Rezoning Transportation Analysis
Petition Number: Insert Zoning Petition #2021-215
General Location Identifier: 03144101

From: Brandon Brezeale, PE
Brandon.Brezeale@charlottenc.gov
704-432-5561

Revision Log:	Date	Description
	01-24-2022	First Review (KP)
	02-21-2022	Second Review (KP)
	03-30-2022	Third Review (KP)

SCHEMATIC SITE PLAN

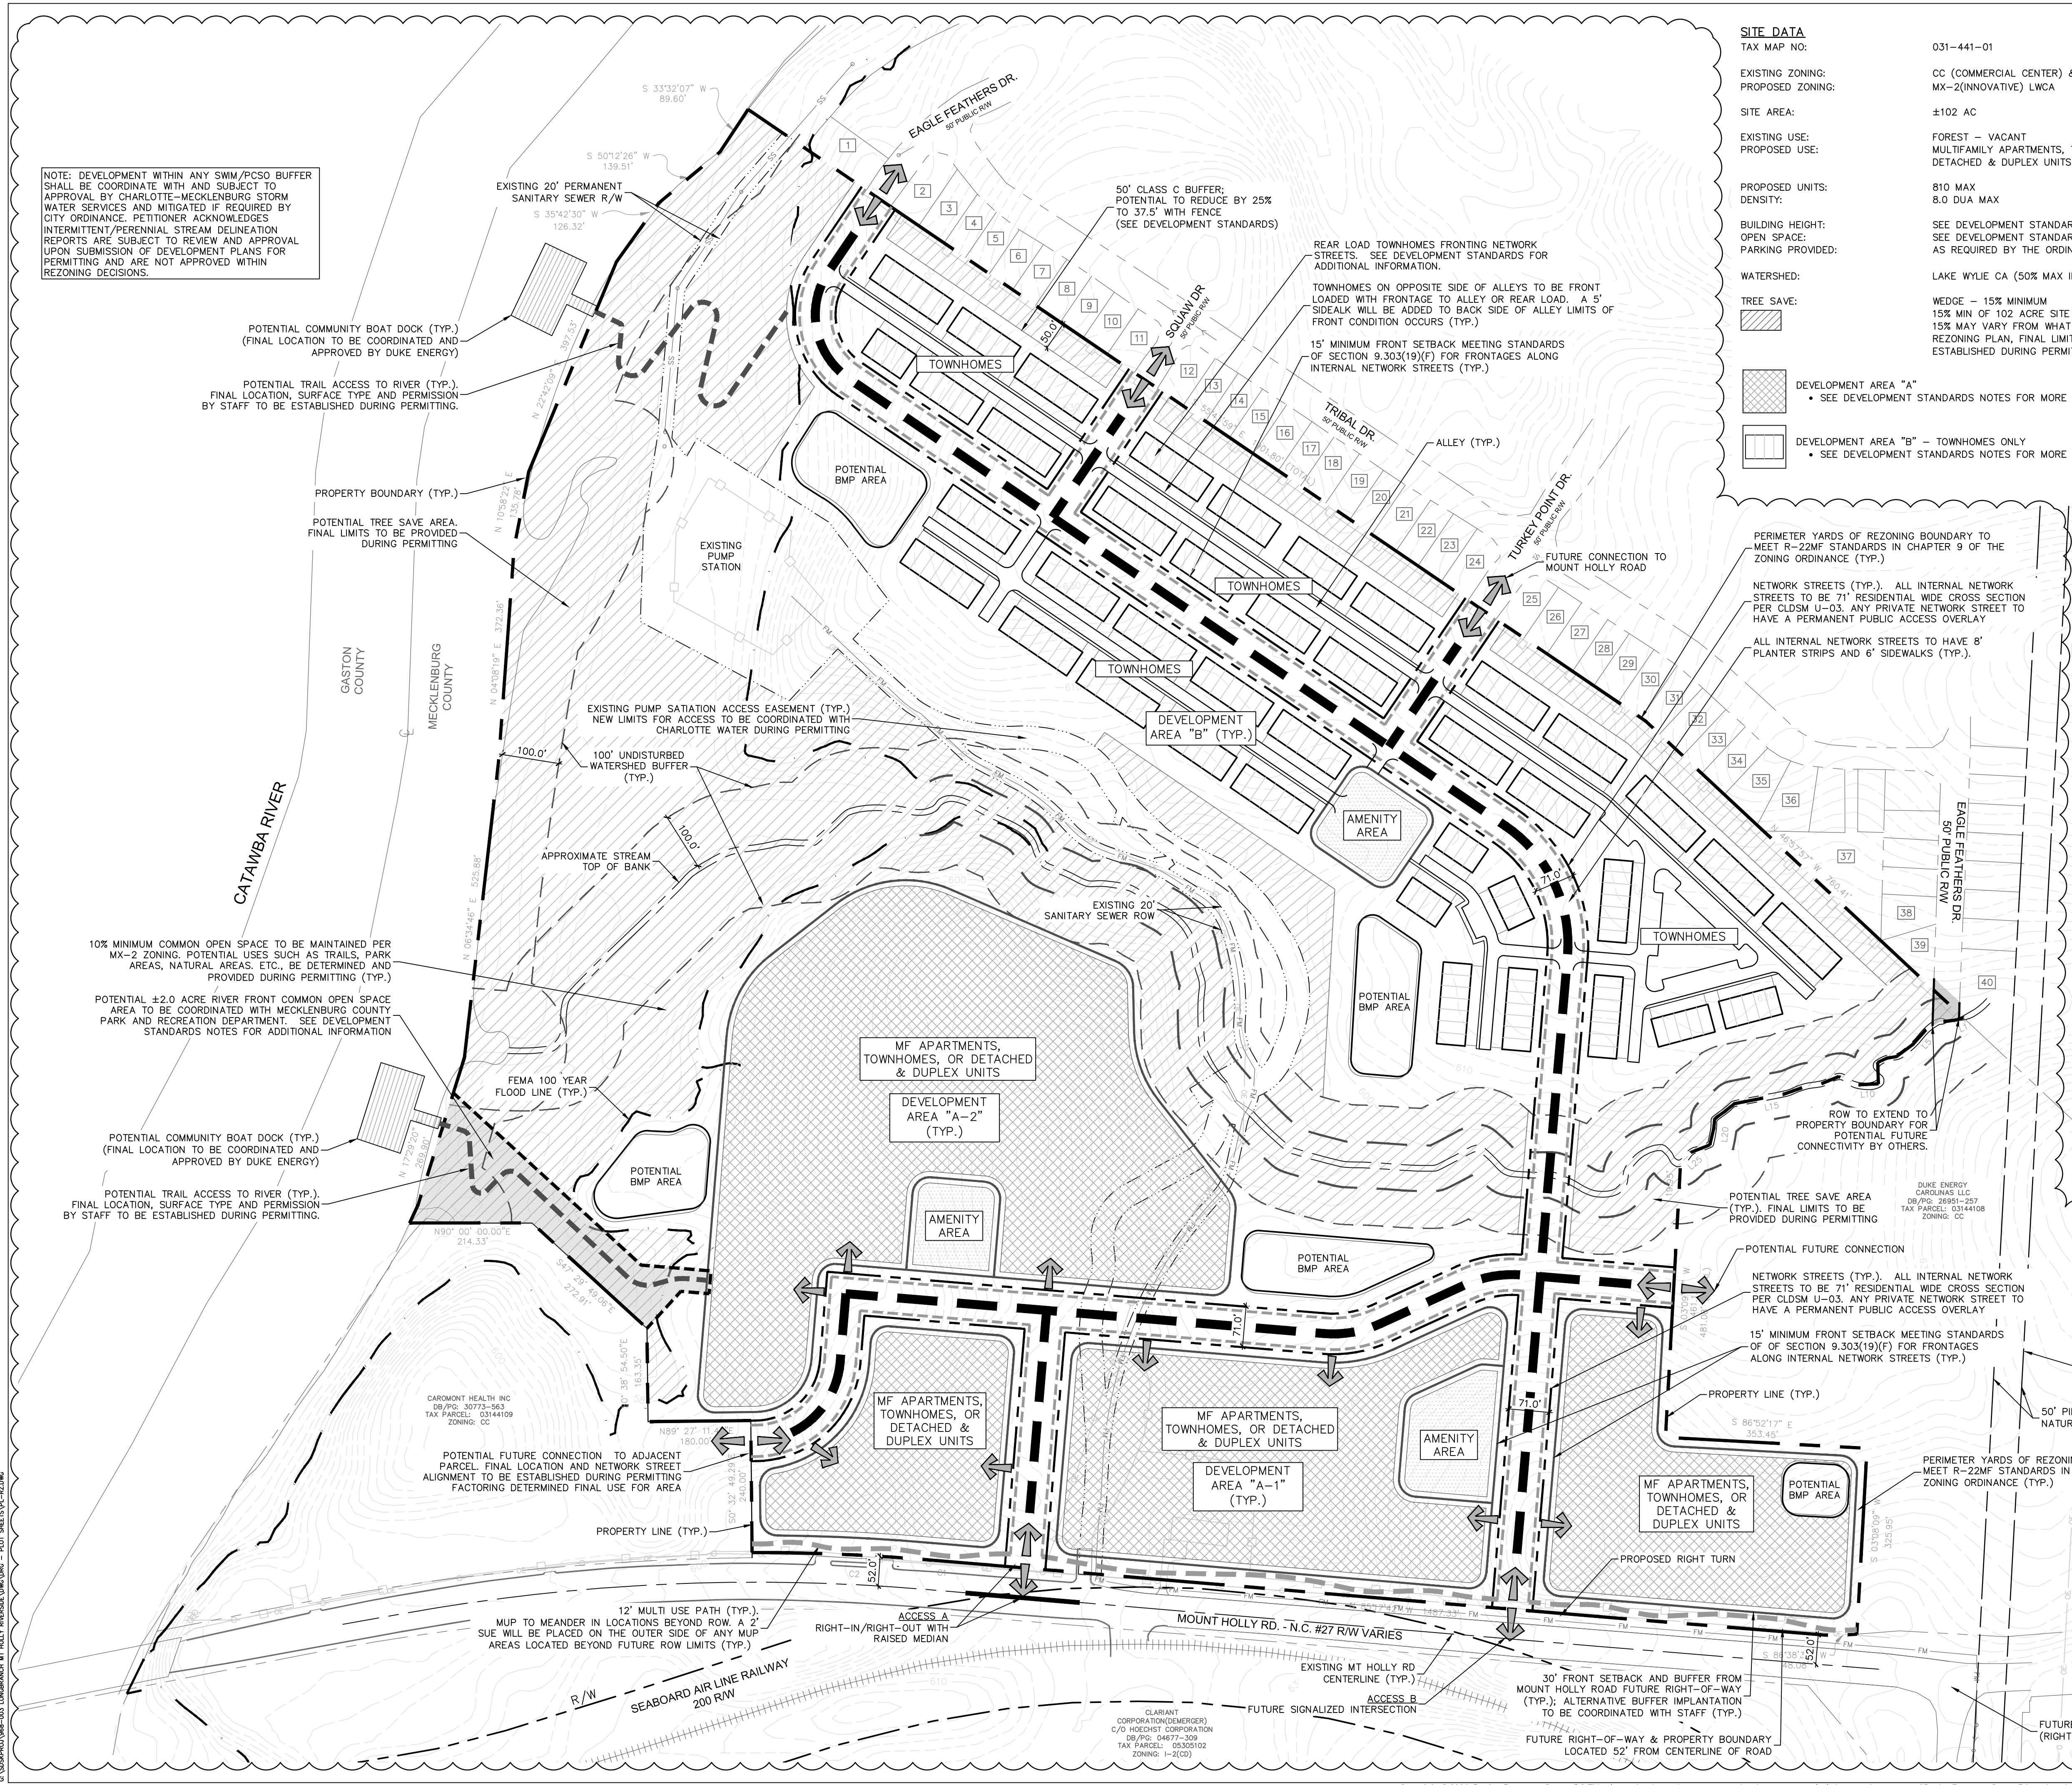
~~Comment rescinded as TIS established improvements will provide varying curb line locations along the site's frontage.~~ Update to Comment as a Result of 02-14-2021 Site Plan: The back of curb will be constructed 30 feet from the existing centerline.

The site plan shall label and dimension the curb and gutter from the existing centerline.
